Memo To: Jean Fraser
Barbara Barhydt
From: David Margolis-Pineo
Re: Development Review Comments for 133 York St.

The Department of Public Services has the following comments.

SITE PLAN MAP 44/BLOCK A/LOTS 29 & 31

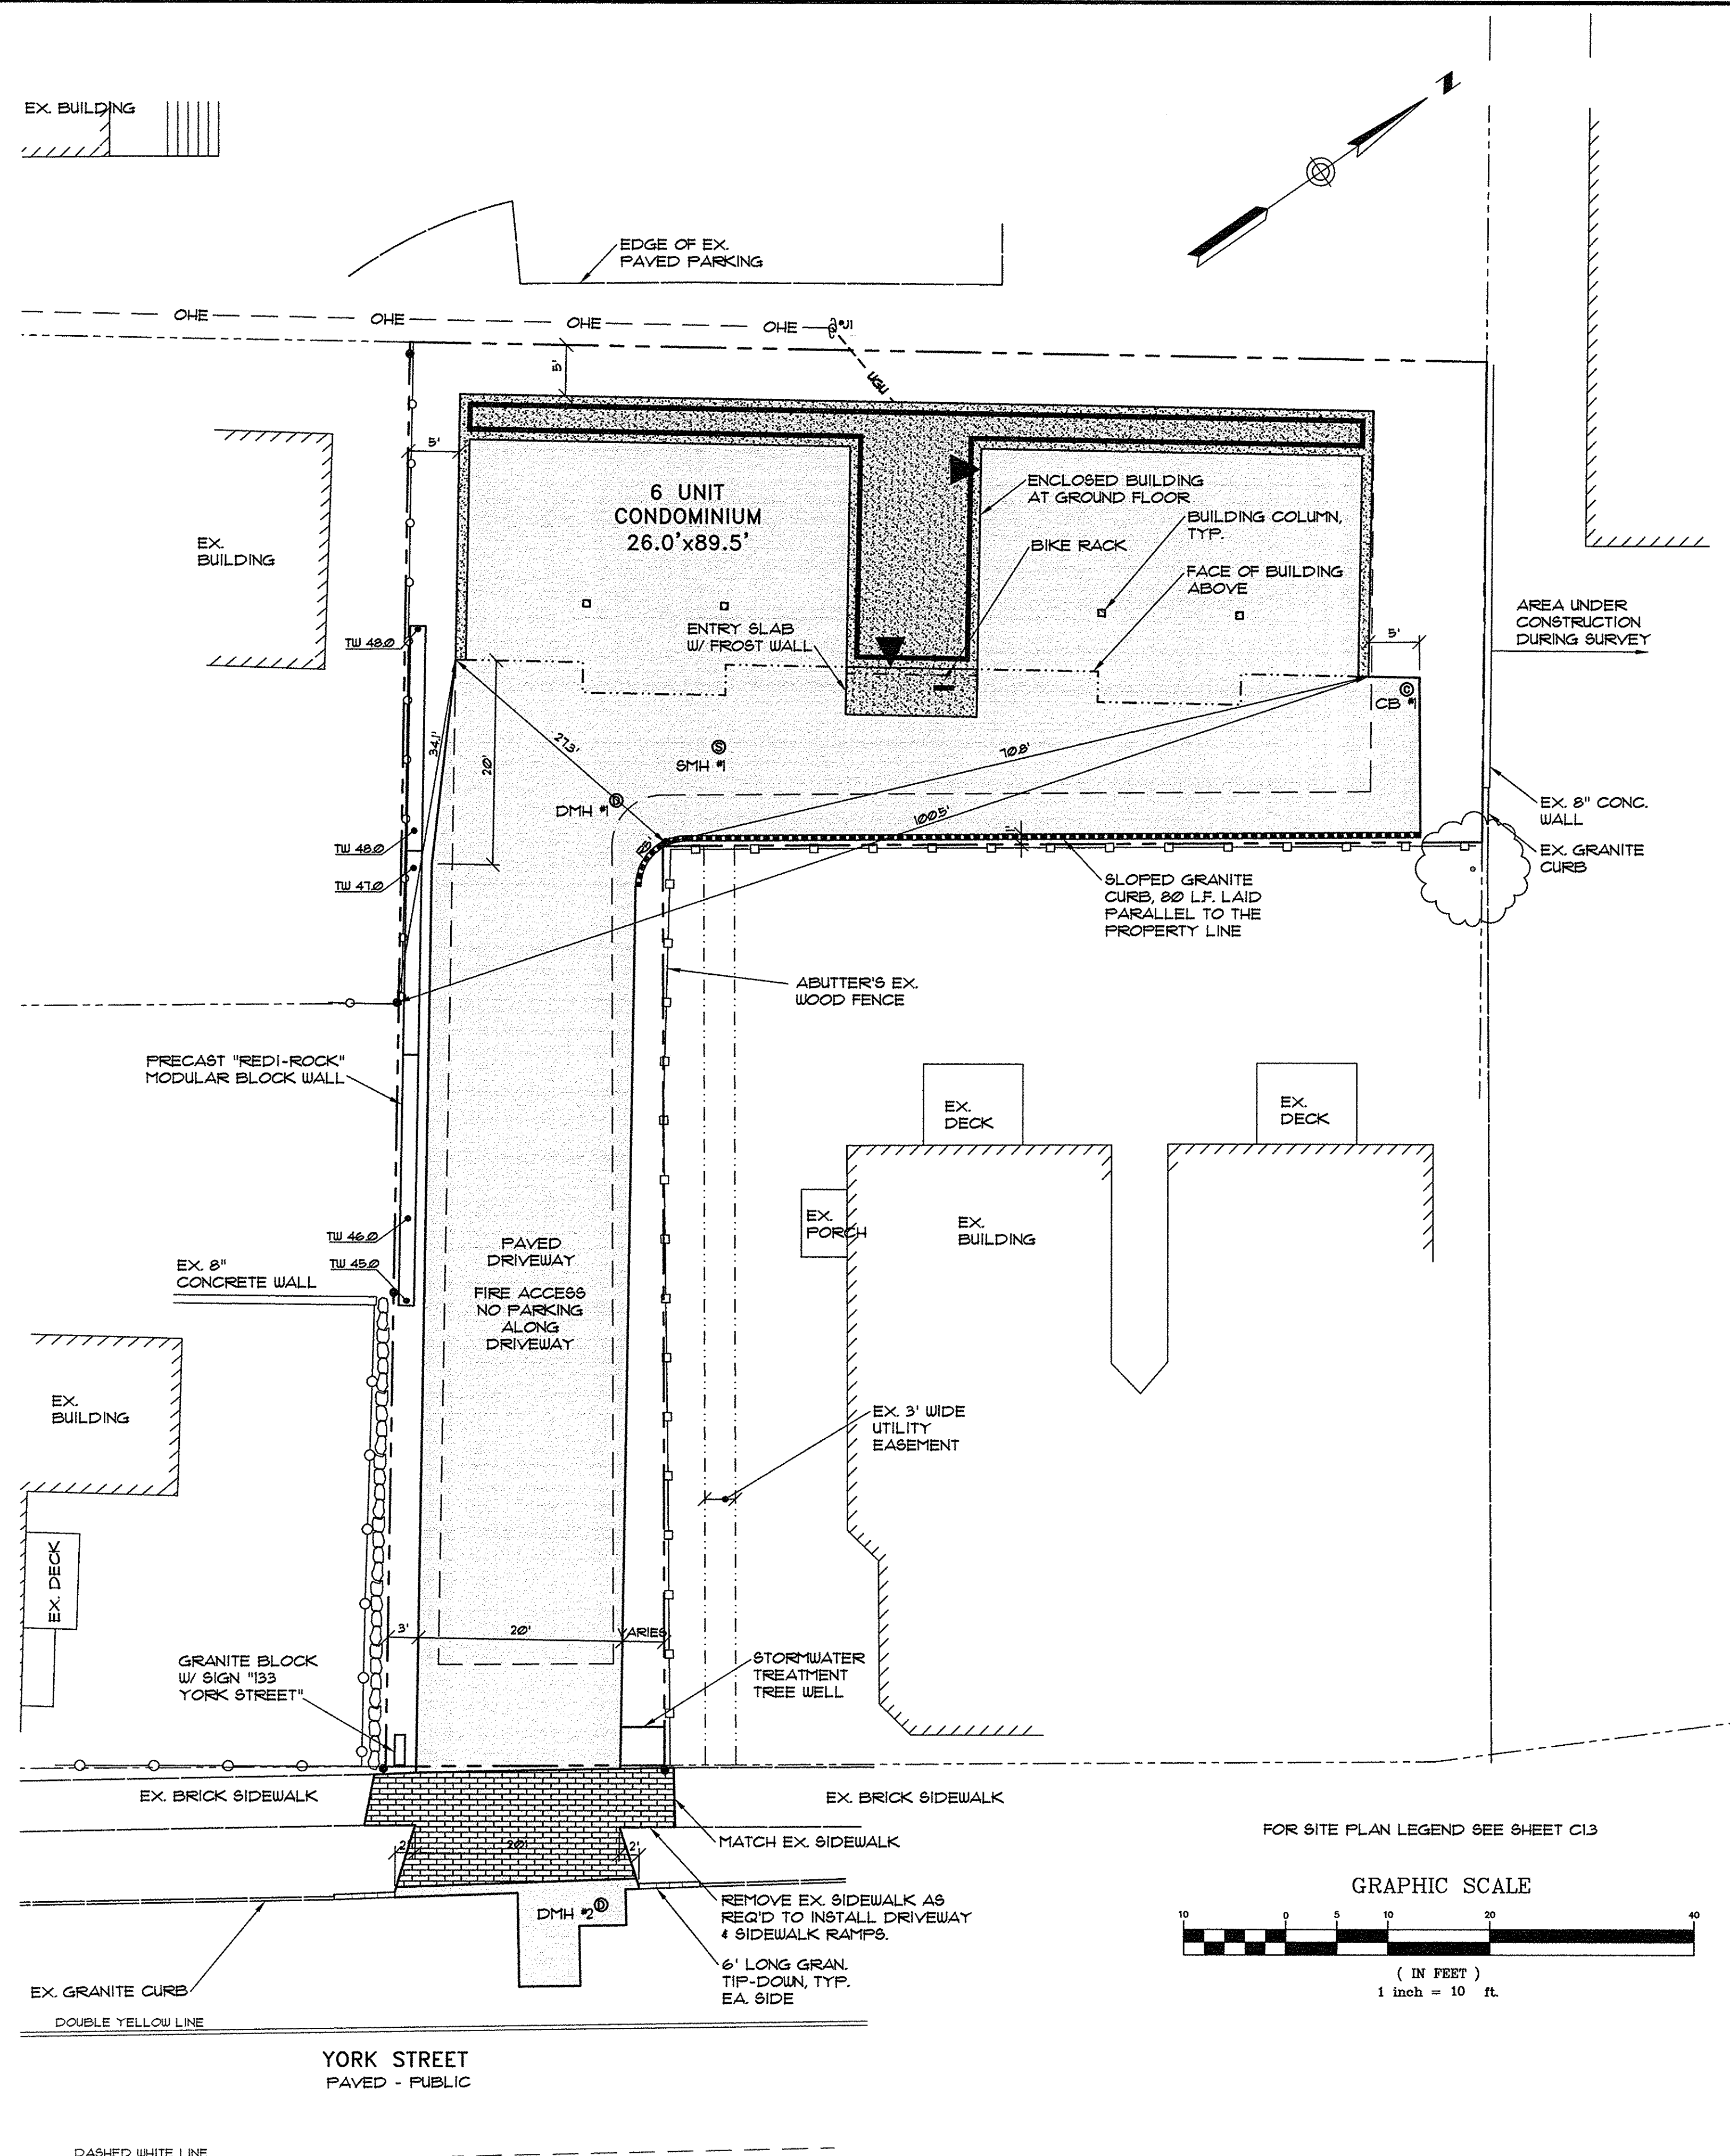
1. Add general note to plans the "All work within the road right of way shall meet City of Portland Technical Manual standards." N-12 drain pipe is not a pipe material which the City allows within the road right of way. SDR-35 is allowed.
2. Survey Comments:
 - a. Please provide State Plane Coordinates and pins, if not present, at all corners
 - b. Survey plan is required to be stamped by a registered land surveyor
 - c. Provide bearing on lines along York St to monument.
3. This location is not in the Historic District therefore the driveway apron material is required to be asphalt and not brick as proposed.
4. Electrical feed is required underground to the site. Current electrical, gas and cable feeds come from Park St. Do easements exist? What are the limits of the underground electric feed? From Park St?
